Your reference: SSD-29508870
Our reference: DOC22/908232

**Advice on Environmental Impact Assessment – State Significant Development – Birriwa
Solar Farm – SSD-29508870**

Attachment A – Detailed Aboriginal Cultural Heritage Advice

Figure 6-2: Location of newly recorded Aboriginal sites.

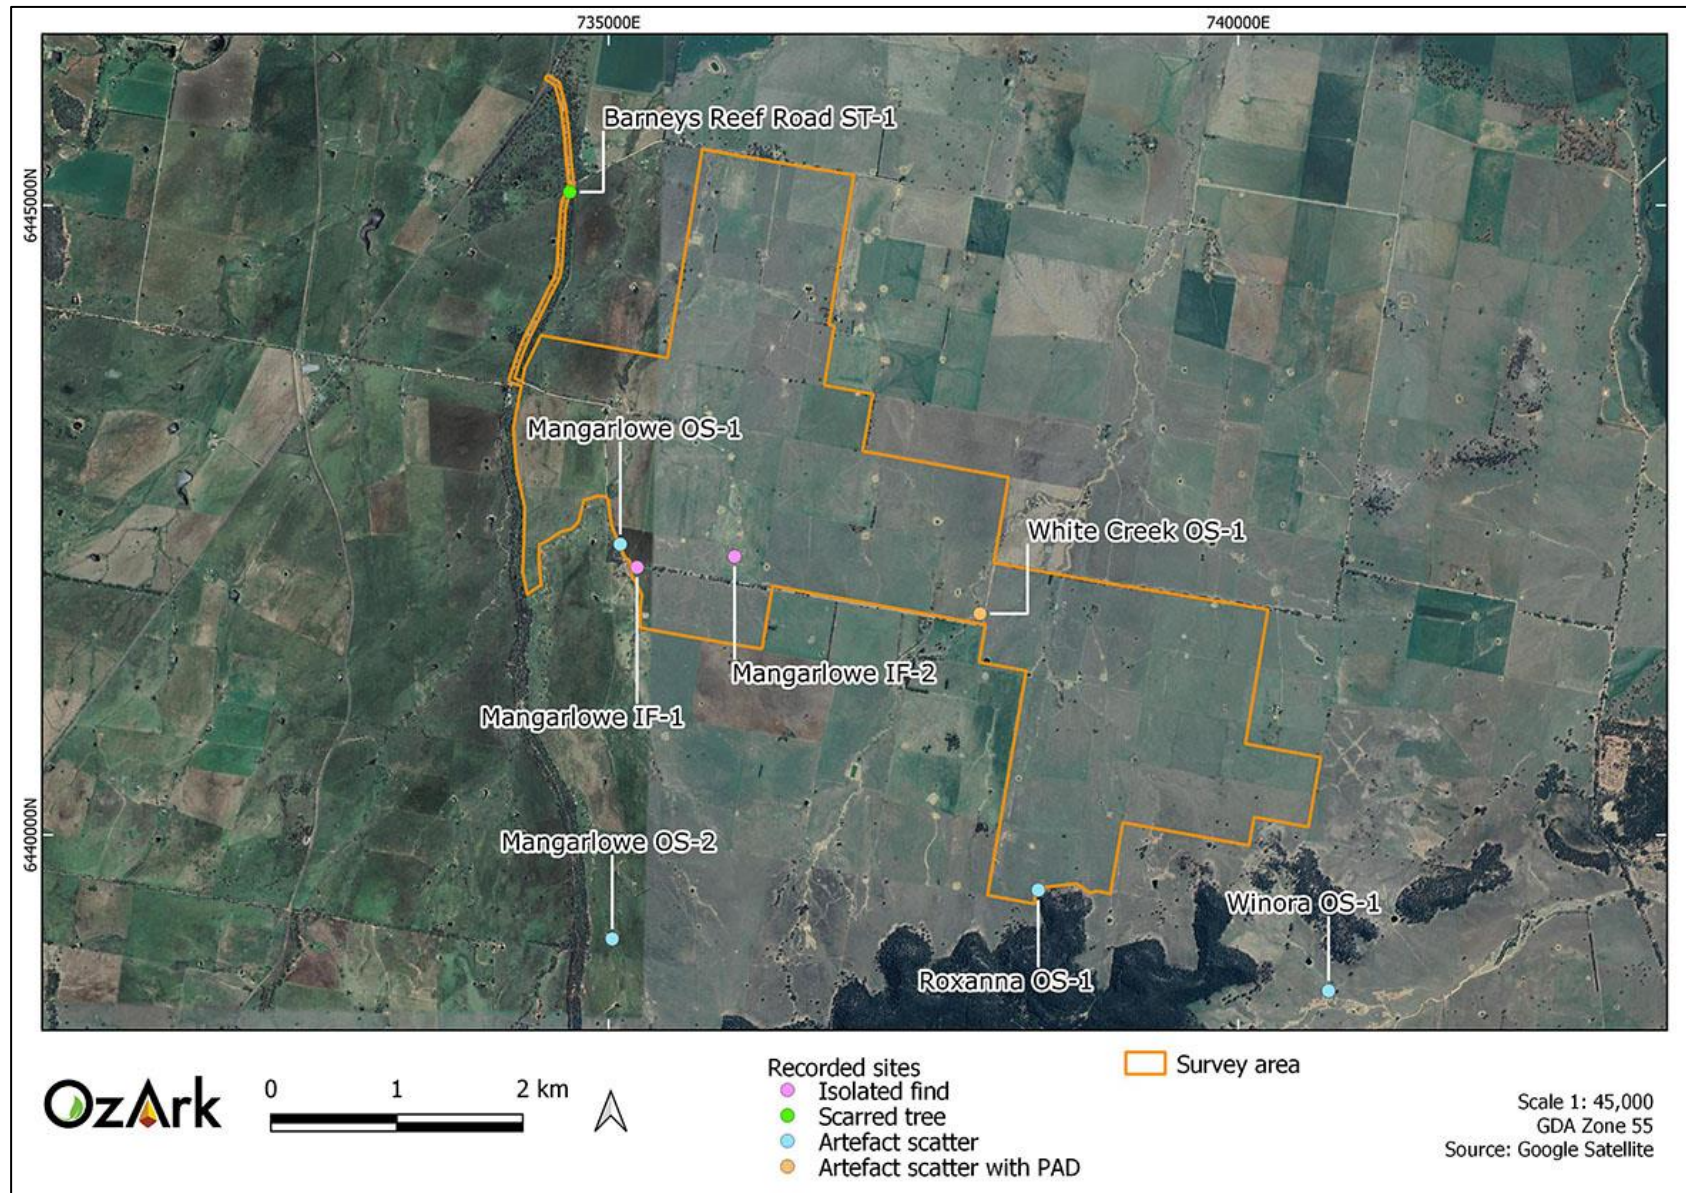
- Further explication is required on the determination of Barneys Reef Road ST-1 (scarred tree) as of low significance. Heritage NSW queries this determination owing to the rarity of such object across the region, its presence in a largely cleared area, and as it is a non-renewable and dwindling aboriginal cultural heritage resource.
- As per Requirement 23 of *Code of Practice for Archaeological Investigation of Aboriginal Objects in NSW* (DECCW 2010) the recording of the site must be consistent with *Aboriginal scarred trees in New South Wales, a field manual* (DEC and Andrew Long 2005). As such, please provide a sketch of the tree and scar that includes the location and shape of scar, location of features (e.g., tool marks), and overall condition of the tree and scar.
